TECHNICAL NOTE

Date:	03/09/2020	Ref:	402.06594.00008 - TN02 v01
Subject:	Middleton Development – Discharge of Surface Water Drainage Conditions Prepared for: Frontier Estates Ltd

This Technical Note summarises the latest work on the surface water drainage strategy that has been developed for the proposed residential development by Frontier Estates Ltd at Yapton Poultry Farm, Middleton-on-Sea, PO26 6DY (Planning M/45/16/PL), in order to discharge planning conditions 11, 13 and 14 of the Planning Consent granted on 07/02/2017.

Figure 4
 Route 1 Plan and Section AA'

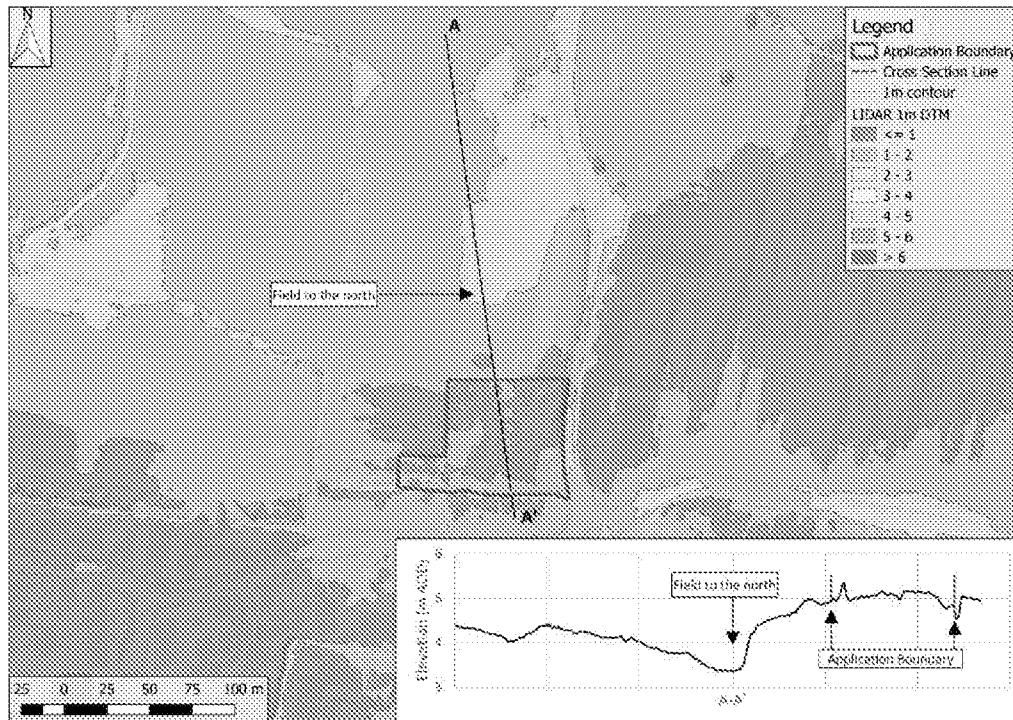
Cross sections from LiDAR provided. Exceedance flow routes from development itself have been provided, it is assumed these are based on proposed levels alone. Further levels indicating proposed levels across the site are required.		See additional proposed levels on the updated SWDS plan in Appendix 01.
iii. Southern Ditches	Site visit/meeting (26/06/2020)	To agree nature and extent of proposals.	SLR attended site with Paul Cann (Arun DC). Summary of agreed comments provided in Technical Note 01 Section 2.3 and Appendix 02.
	To be reviewed further once network calculations have been supplied and as part of the land		Ditch outfall level reviewed and updated in Appendix 01.

The drainage detailed design has been supplemented with a highway design that has allowed finished formation levels to be set out for the site. These levels are now shown on 402.06594.00008.001 P1 Proposed Drainage Layout shown in **Appendix 01**.
